An Bord Pleanála Oral Hearing

Greater Dublin Drainage Application

Submission by
Conroy Crowe Kelly Architects & Urban Designers
and
Waterman Moylan Consulting Engineers

on behalf of
Gannon Properties

Drawing file: GDD Planning Drawings / 32102902-2148_P01  Proposed Culvert at Mayne River Crossing - WwTP Access Road (Sheet 1 of 2).pdf

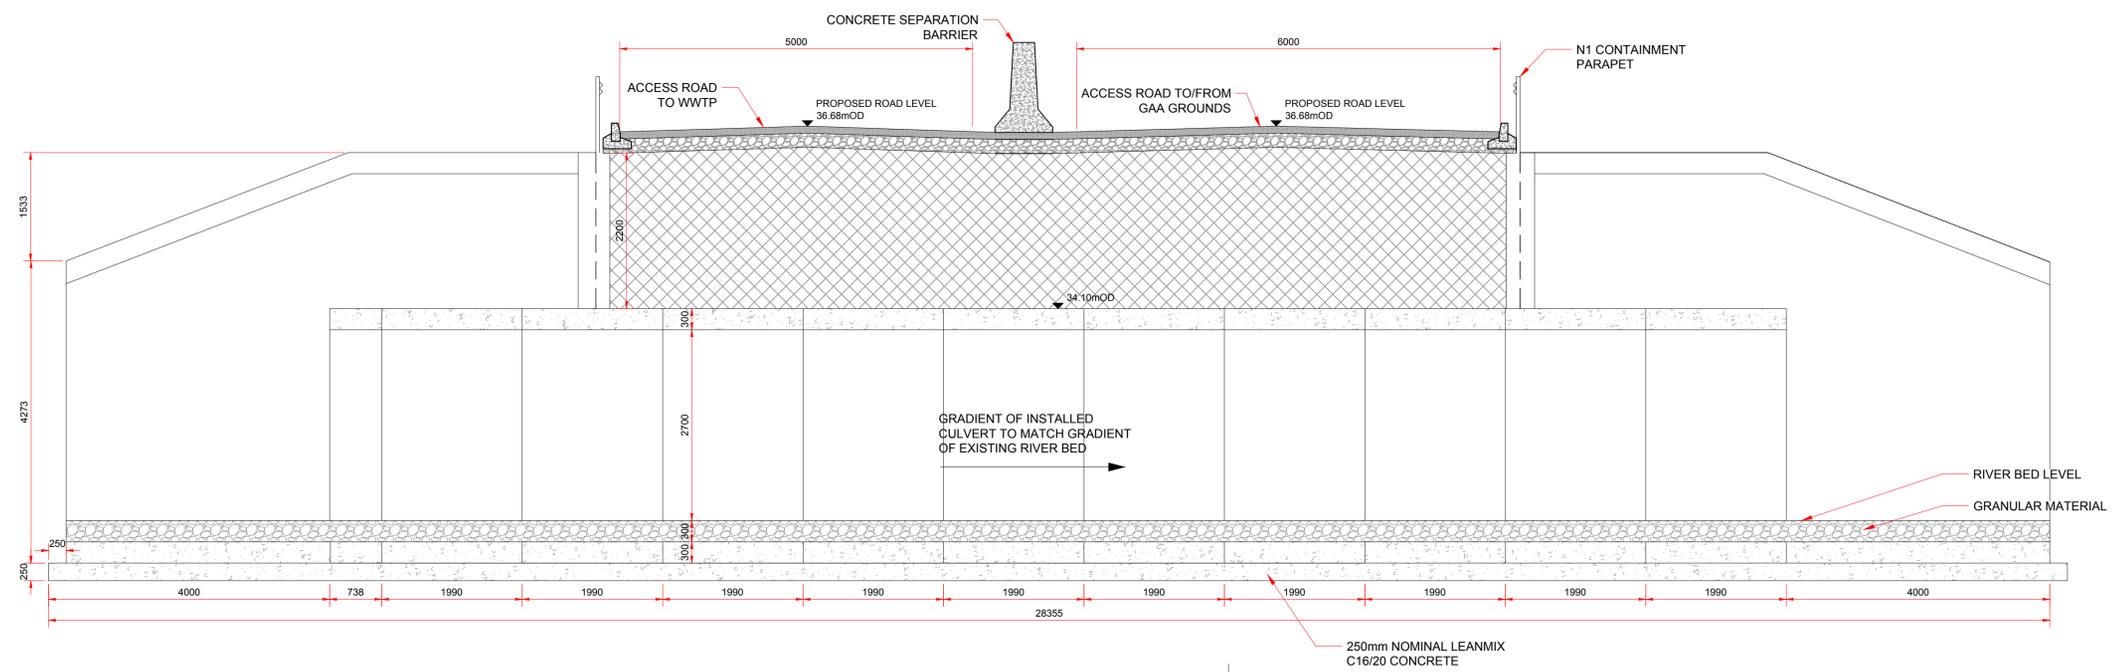
- 1.22 We would respectfully suggest that any grant of permission for the WwTP includes a condition that requires the north-south link road connecting the R139 to the EWDR, including the Mayne River culvert, to be constructed to the distributor road standard proposed by the Atkins scheme and in accordance with the objectives of the Dublin City and Fingal County Development Plans.

VIEW TOWARDS RIGHT (WEST) FROM PROPOSED SITE ACCESS ON R139

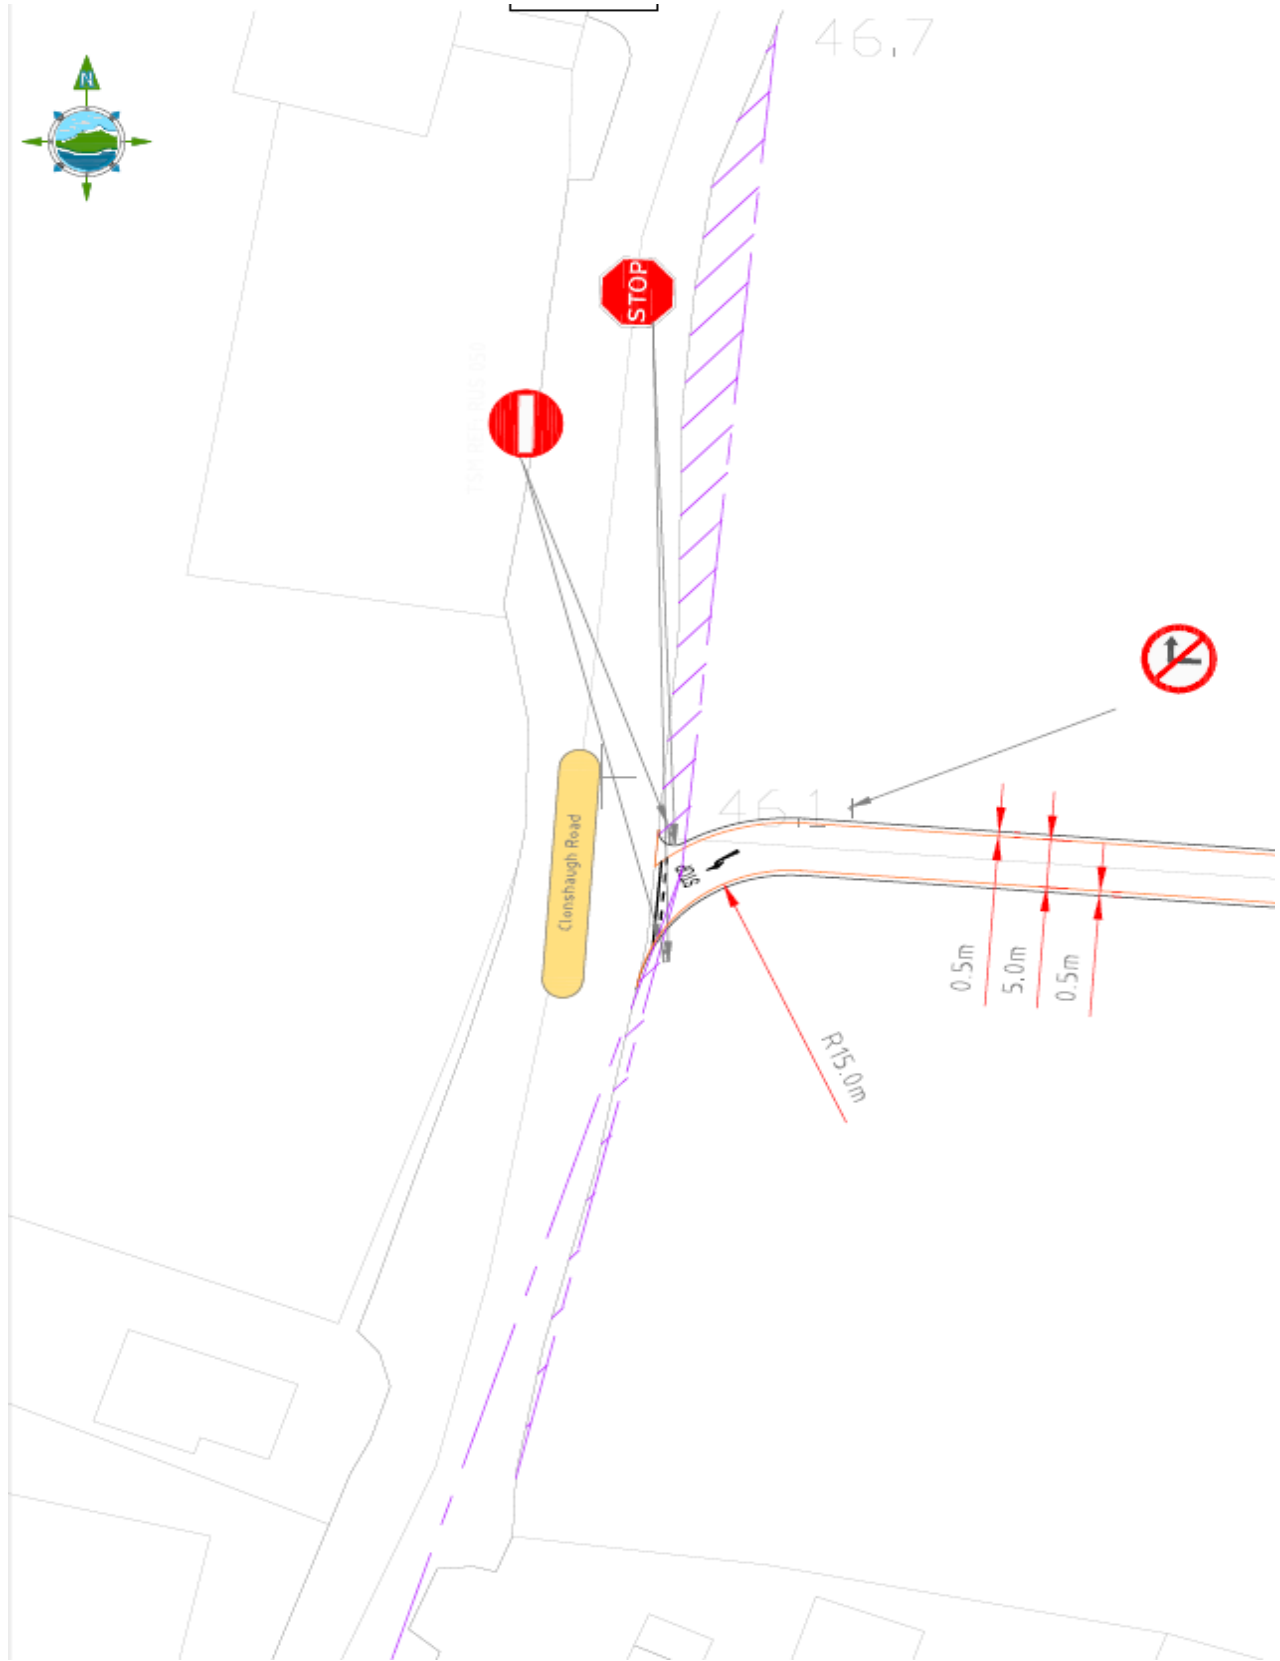
2.7 The proximity of these junctions will significantly reduce the safety of all road users unless the junction at Cora Park is signalised and pedestrians and cyclists provided for. Conflicting right-hand turn movements from GAA lands and Cora Park pose a significant hazard to road users.
